WEST SUSSEX COUNTY COUNCIL CONSULTATION

TO:	Arun District Council FAO: Simon Davis
FROM:	Highways, WSCC
DATE:	23/04/2018
LOCATION:	Land adjacent to Bonhams & Flints, Hoe Lane, Flansham, PO22 8NP
SUBJECT:	Y/20/18/OUT Outline application with some matters reserved for the erection of 10 dwellings with access from Hoe Lane, Flansham (resubmission following Y/40/17/OUT). This application is a Departure from the Development Plan.
DATE OF SITE VISIT:	
RECOMMENDATION:	
S106 CONTRIBUTION TOTAL:	See below for breakdown.

Additional Comments

Scale: 1:250	Drawn by: SMO	Checked by: ALB	Approved by: PMR
Date: March 2018	Working Title: 2017/3615/001	Sheet: F

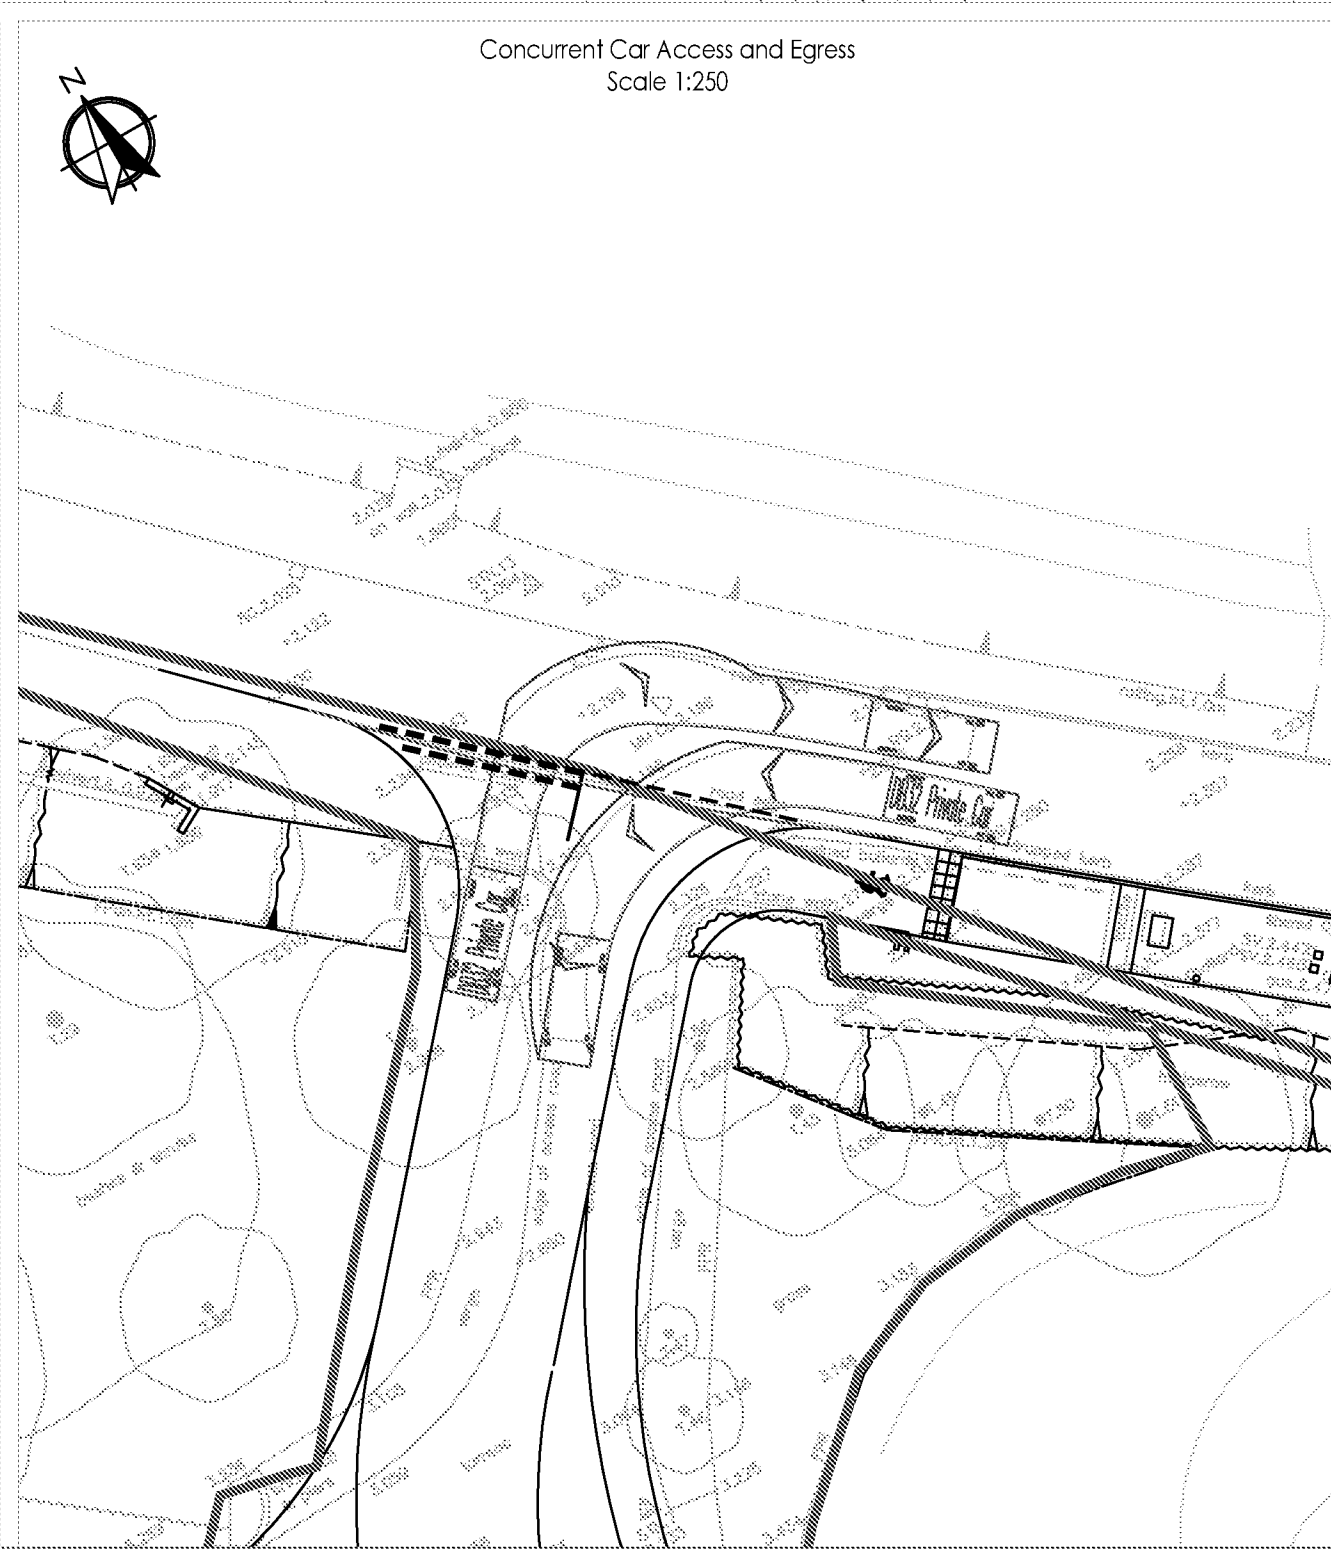
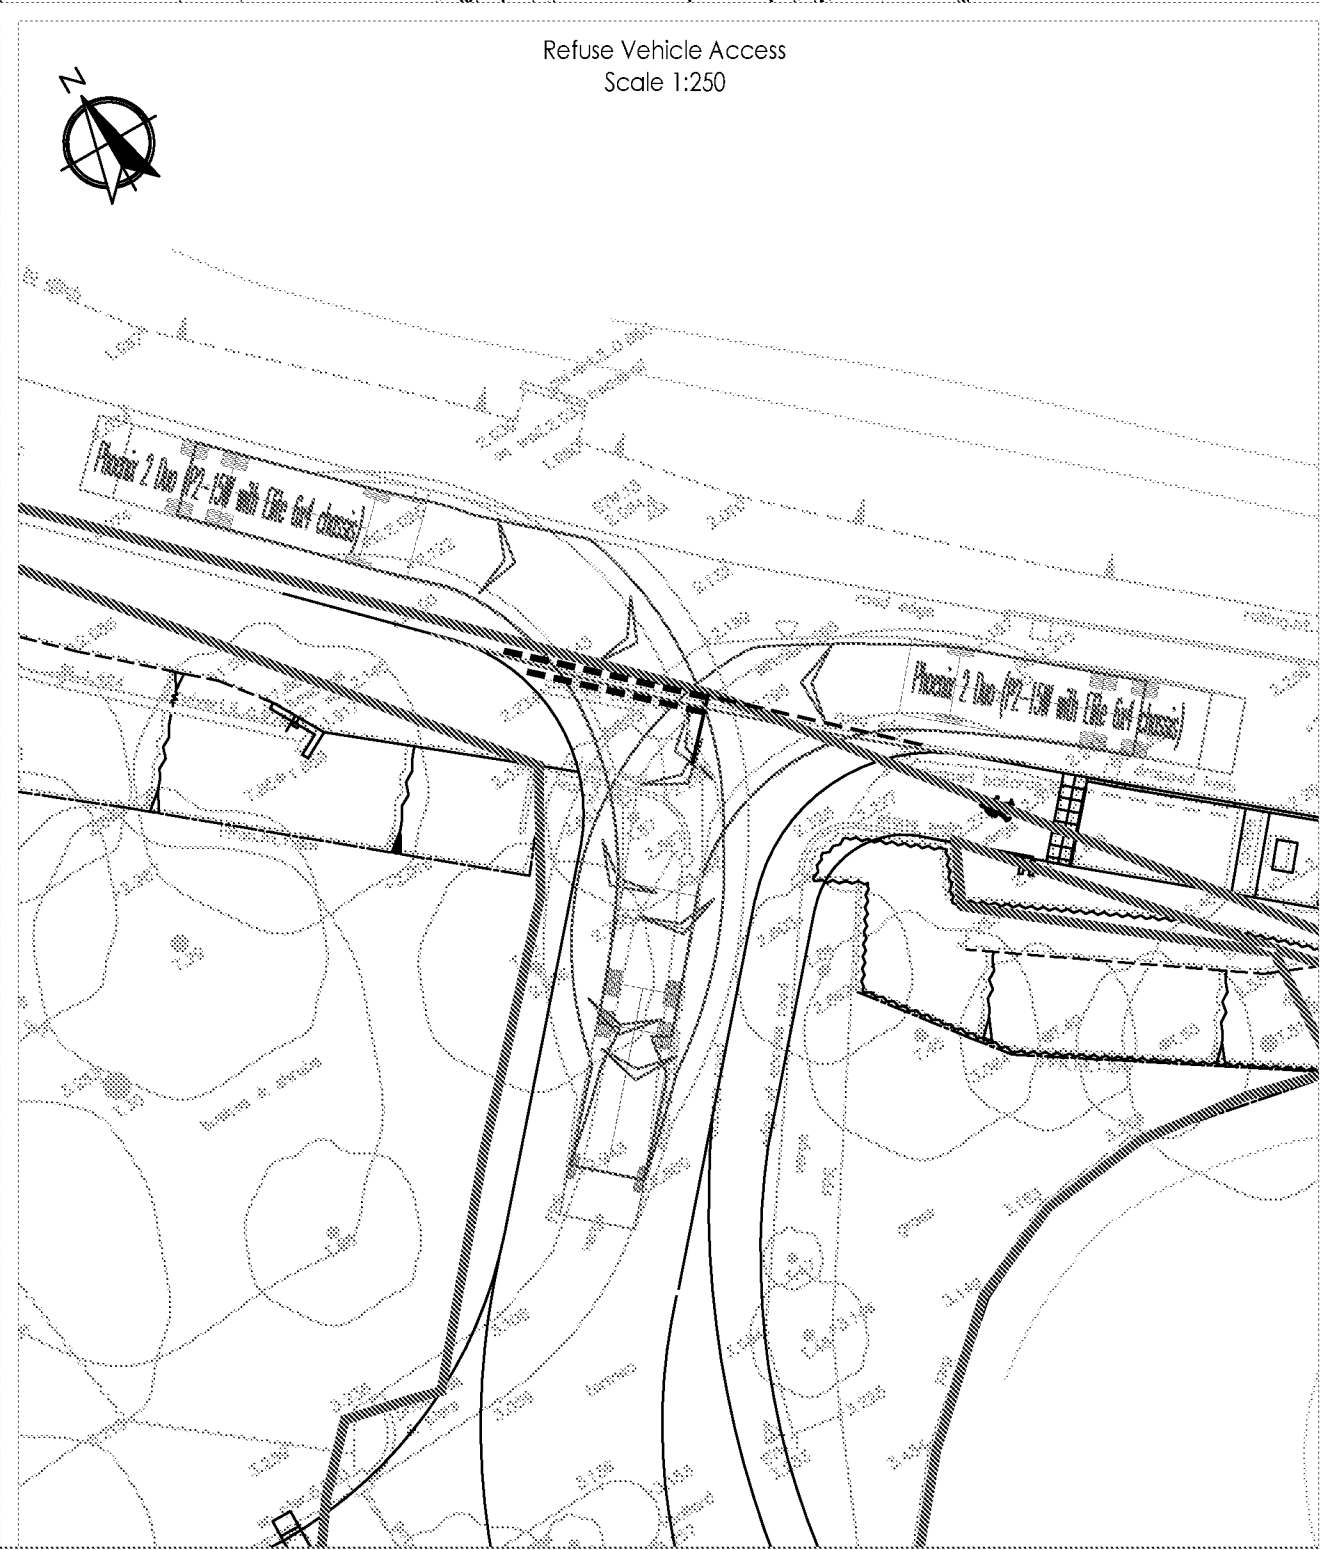
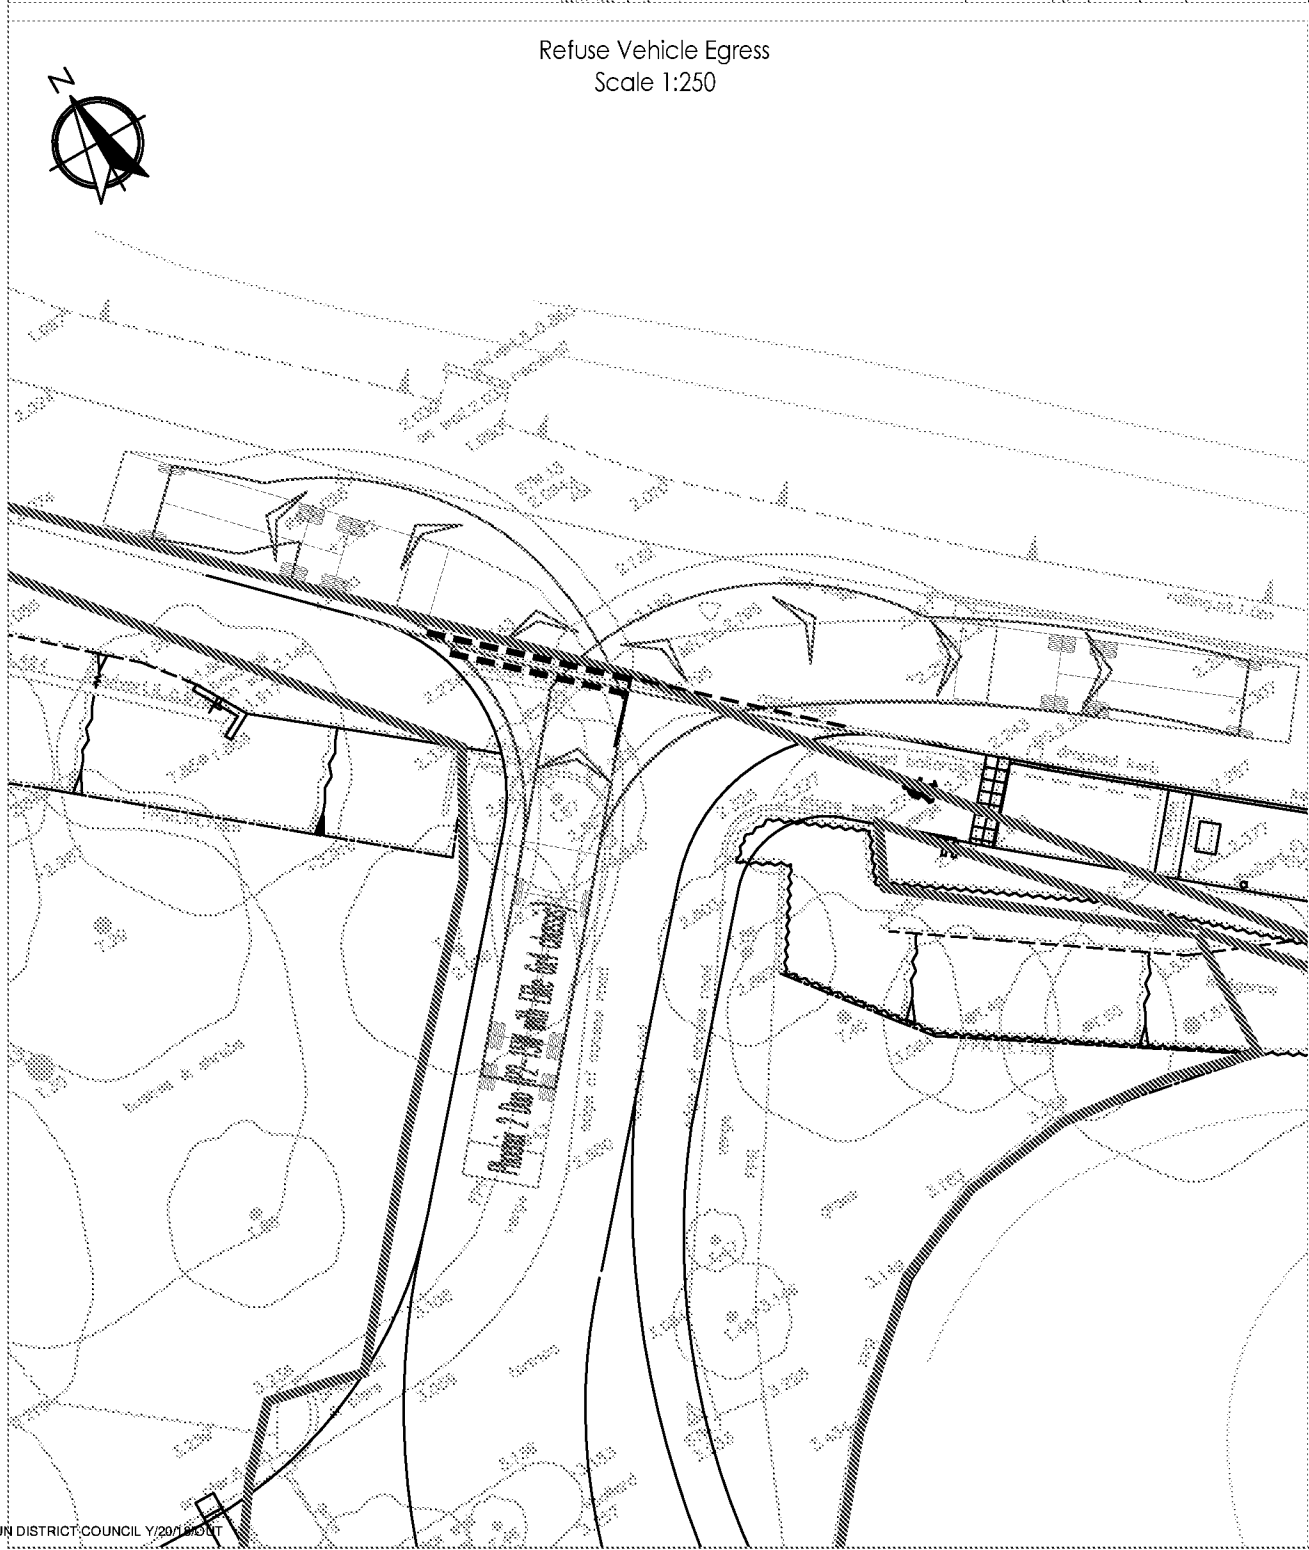
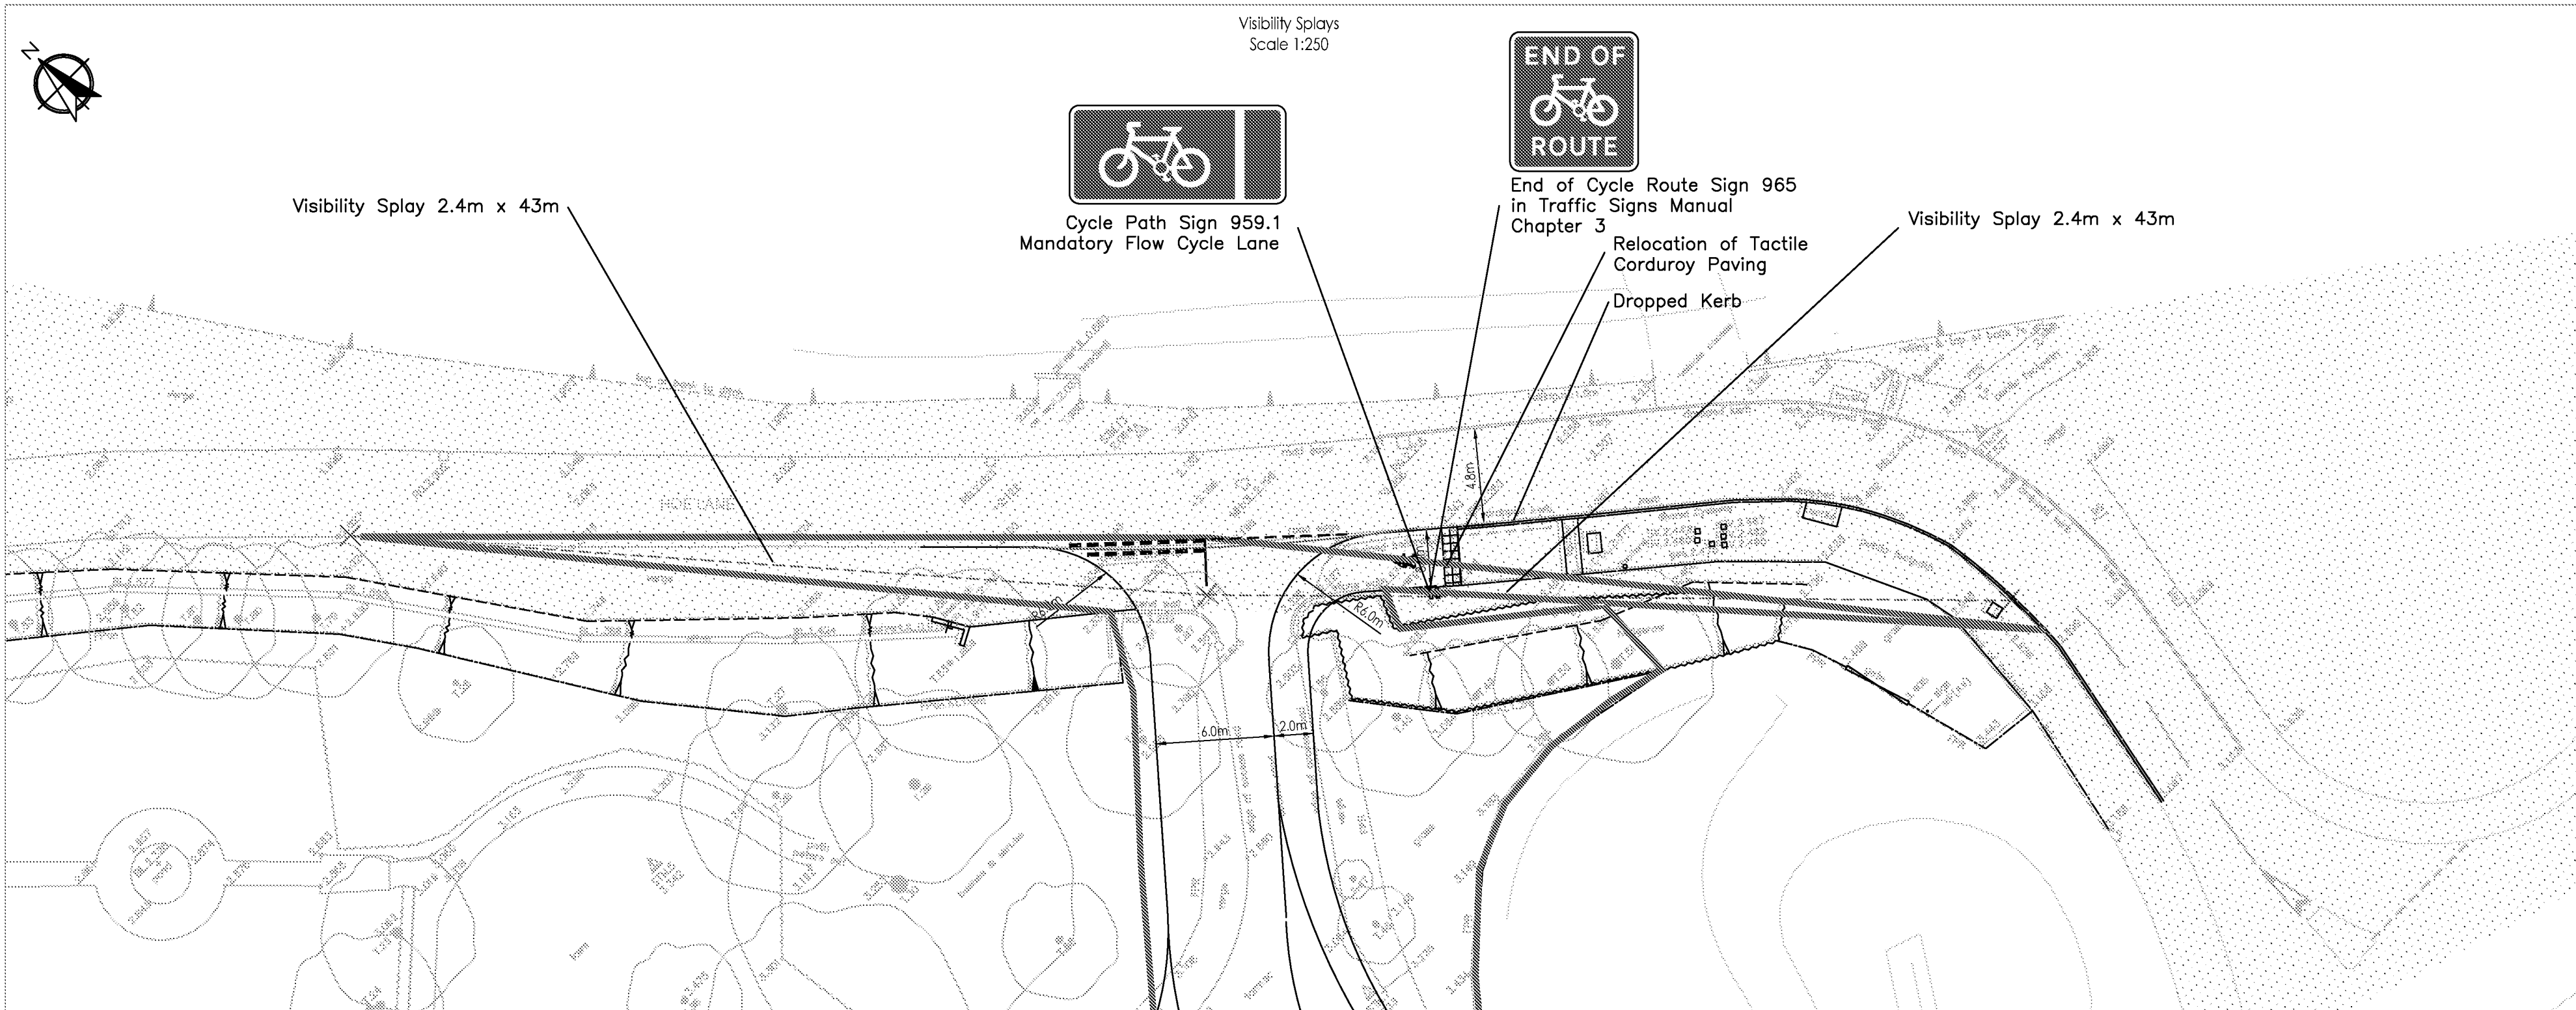
- Drawing number-2017/3615/001 Rev F. This plan shows visibility splays, proposed cycle path signs and vehicles entering and existing the site in the forward gear. The LHA are satisfied with the proposed plans,

the splays are within the parameters of Manual for Streets (MfS). The Signs can be dealt with at the Stage 2 aspect of the application.
